**KITTTITAS COUNTY**  
**DEPARTMENT OF PUBLIC WORKS**

**MEMORANDUM**

TO: Community Development Services  
FROM: Taylor Gustafson, Environmental/Transportation Planner  
DATE: May 11, 2018  
SUBJECT: Suncadia Phase 1, Division 15 LP-18-00001

**The following shall be conditions of preliminary approval.**

JOB NO.:	998-766-017
DWG. NAME:	PP-01
DESIGNED BY:	JJH
DRAWN BY:	LGB
CHECKED BY:	
DATE:	03/20/2018
PRINT DATE:	
SHEET	
PP-01

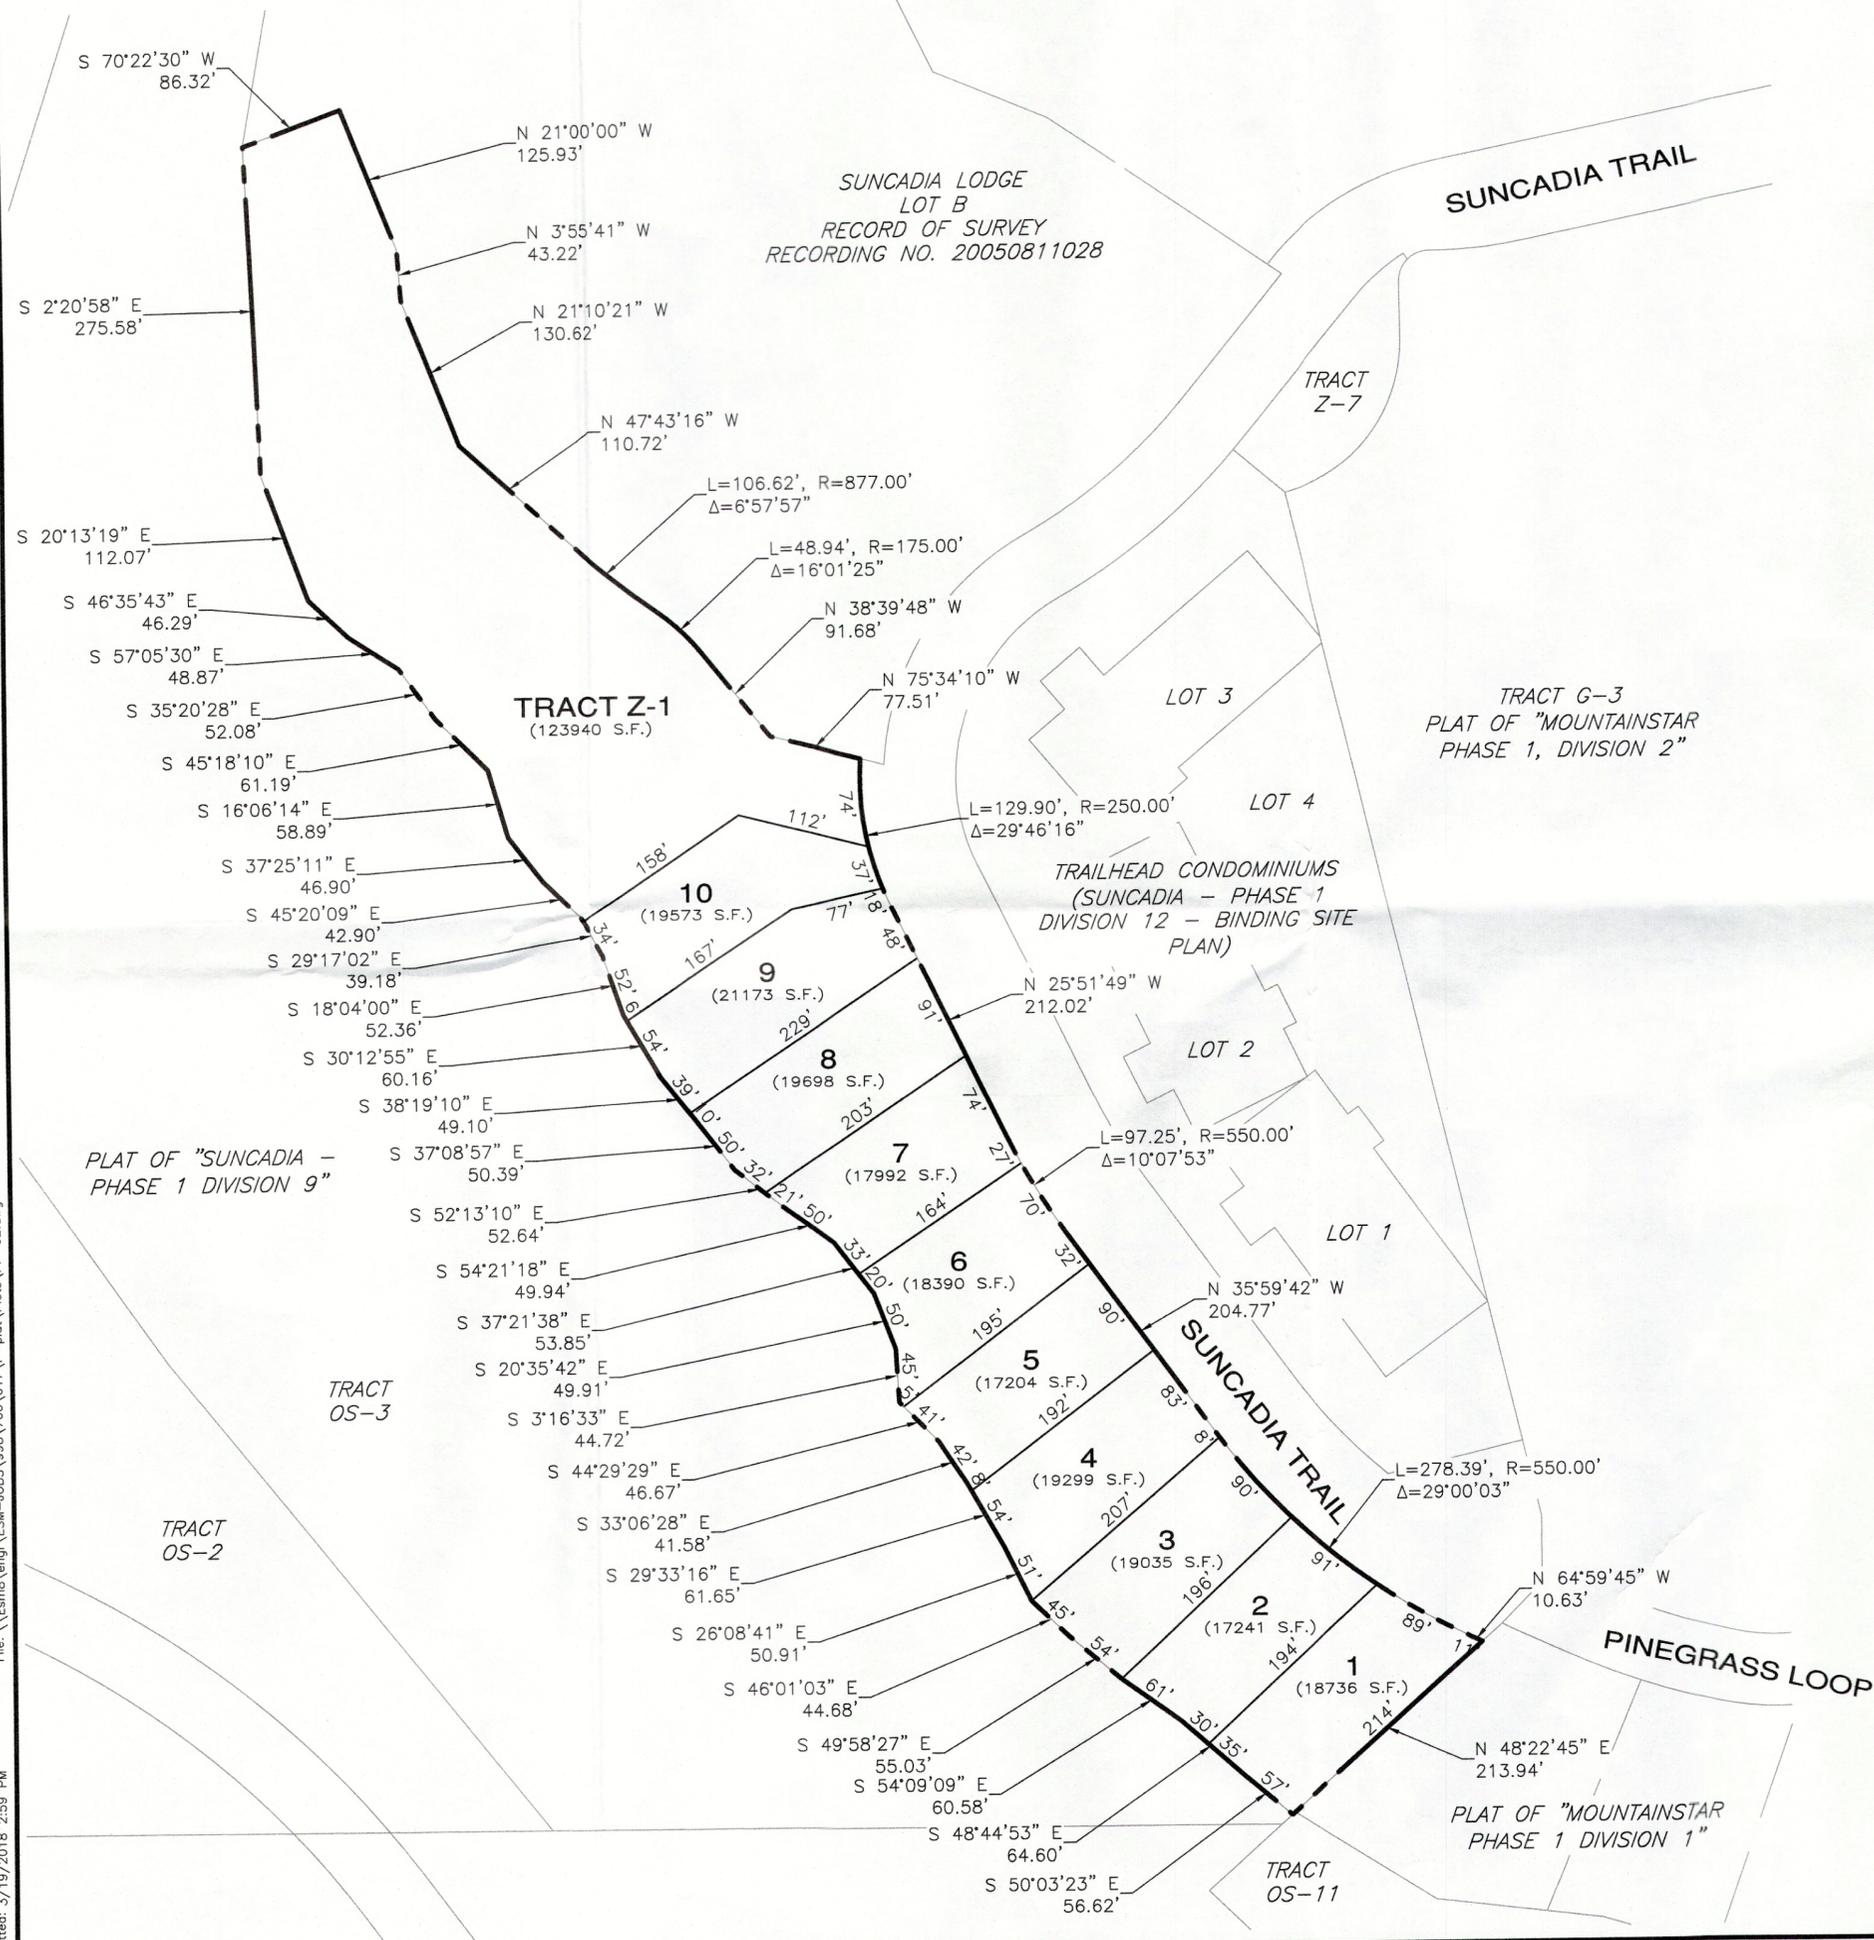
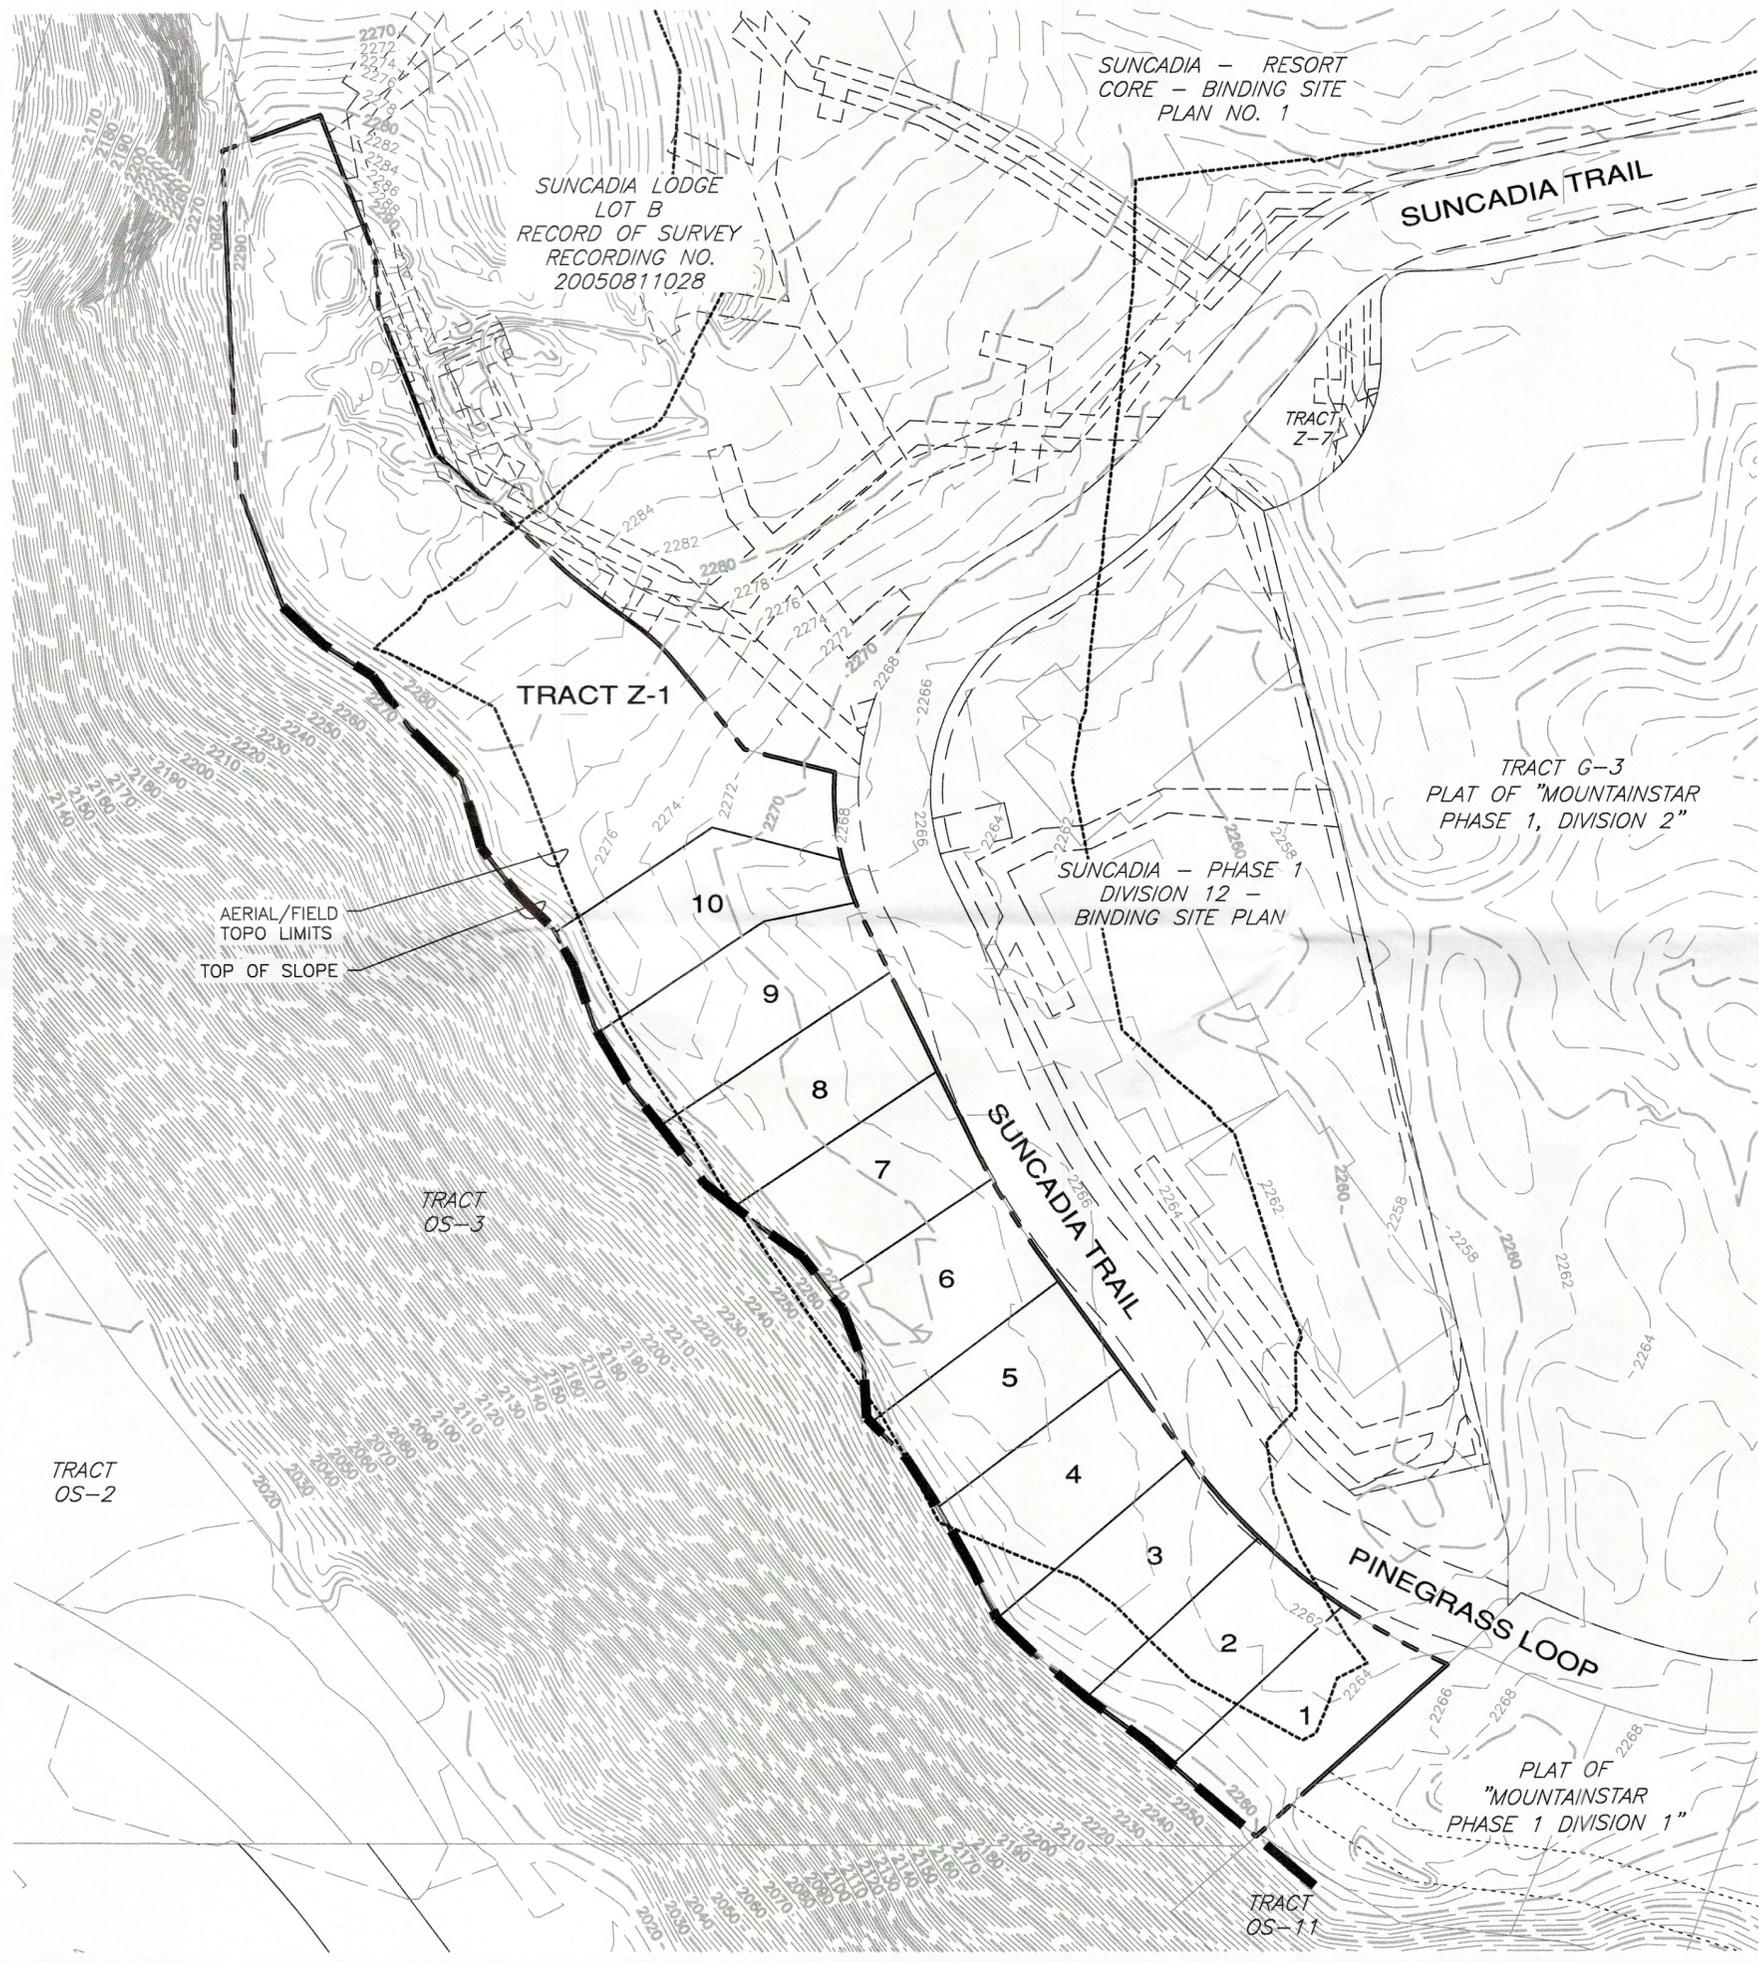
1. The submitted Preliminary Plat does not contain the name of the Surveyor/Engineer responsible for preparing the documents.(KCC 16.12.020(5))
2. Roadways should show name, width, and type (private roadway–paved). (KCC 16.12.030(2)).
